Permit Reviews

Permit Number: BRES2510-0006

Description: 11x19 residential sunroom

Site Address: 58 NAVAHO TRL

ROOF PLAN

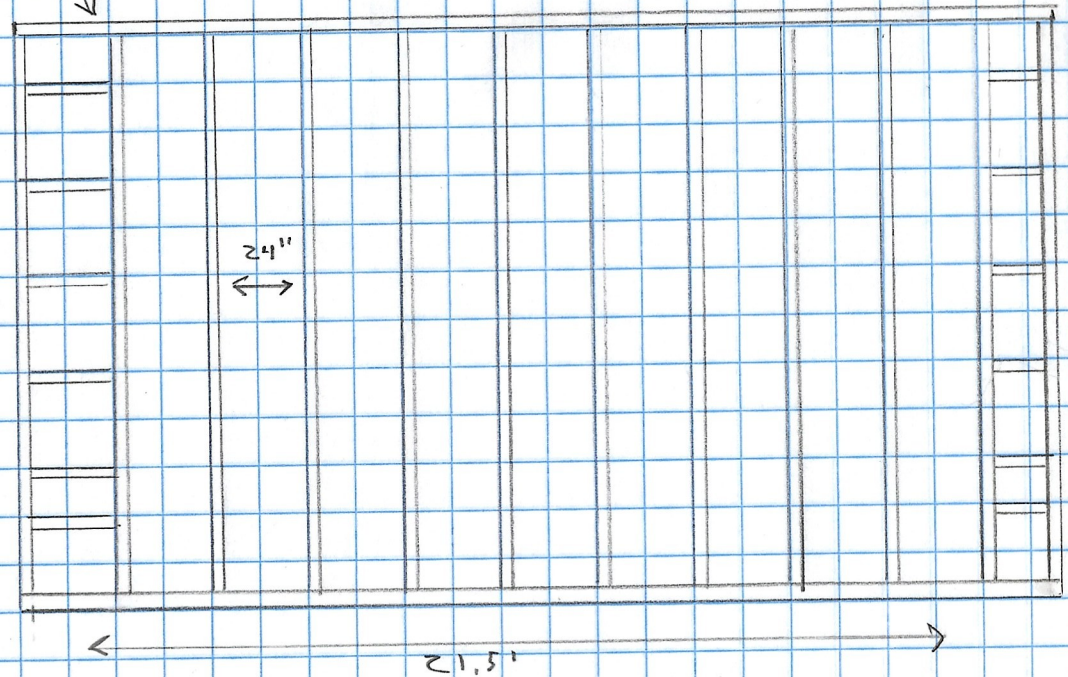
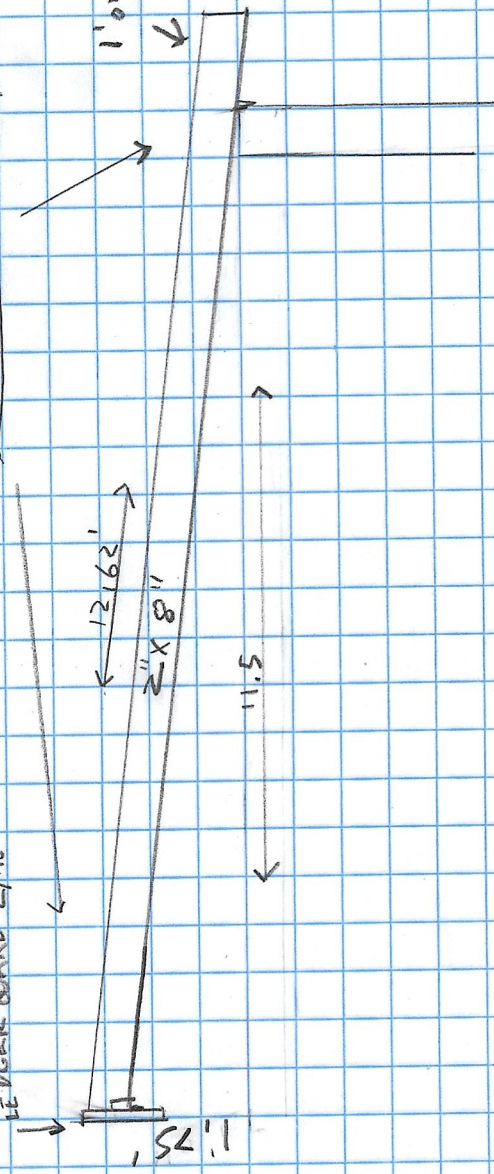
SENT DATE	RETURNED DATE	DUE DATE	TYPE	CONTACT	STATUS	REMARKS
Review Group: 1ST PLAN REVIEW						
10/13/2025		10/27/2025	ENVIRONMENTAL	EH Bucket		
Notes:						
Review Group: AUTO						
10/2/2025	10/2/2025	10/3/2025	CENTRAL PERMITTING INTAKE	CP Bucket	APPROVED	
Notes:						
10/2/2025	10/6/2025	10/7/2025	RESIDENTIAL BUILDING	Brad Sutton	DISAPPROVED	in attachments
Notes: provide wall framing/bracing method Provide header sizes over opening for windows/doors provide roof covering material. Roof slope is less than 2:12						
10/6/2025			RESIDENTIAL BUILDING	Building Bucket		
Notes:
